HRG: responses to comments

EL PASO COUNTY GRADING AND EROSION CONTROL PLAN CHECKLIST

EPC Project Number: PUDSP236

EARLY GRADING & EROSION CONTROL PLANS  
 GEC INITIAL

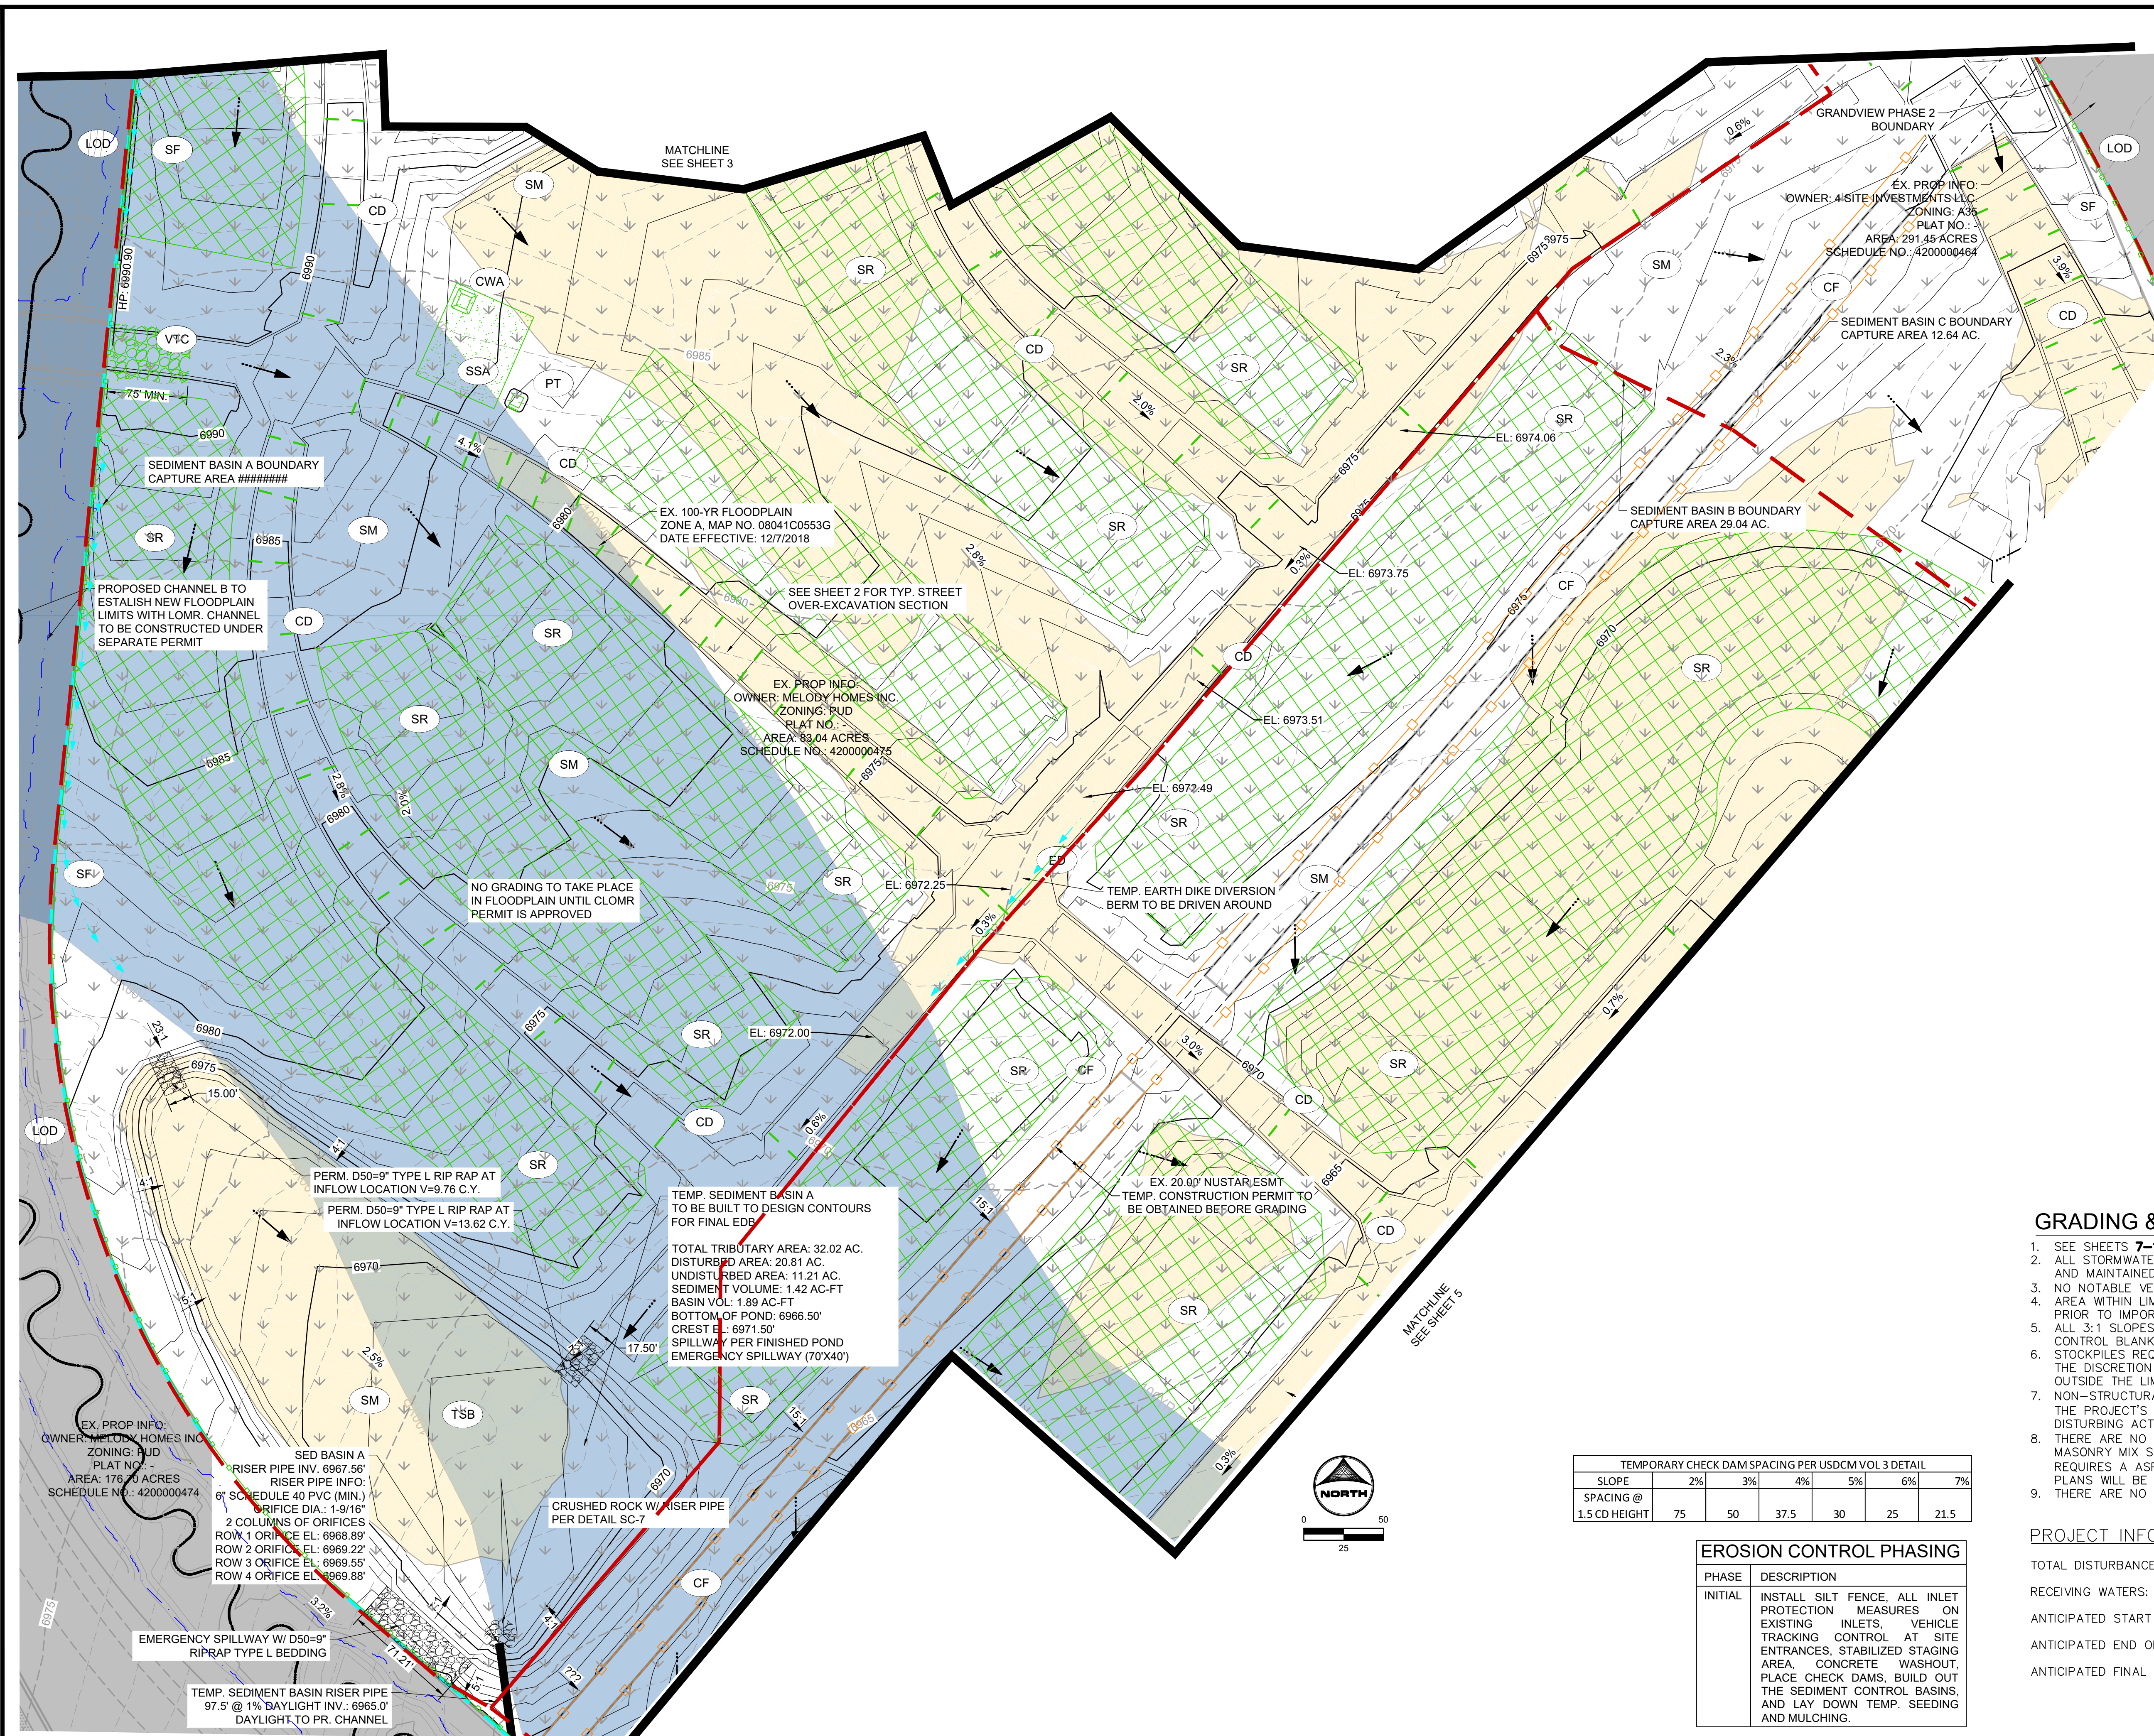
v	All proposed temporary construction control measures, structural. Temporary construction control measures shall be identified by phase of implementation to include "initial," "interim," and "final" or shown on separate phased maps identifying each phase		Y
w	Vehicle tracking provided at all construction entrances/exits. Construction fencing, barricades, and/or signage provided at access points not to be used for construction	See my comment on Sht 3	N
x	Temporary sediment ponds provided for disturbed drainage areas greater than 1 acre		Y

HRG RESPONSE: LIMITS AREA UPDATED TO 69.1 ACRES
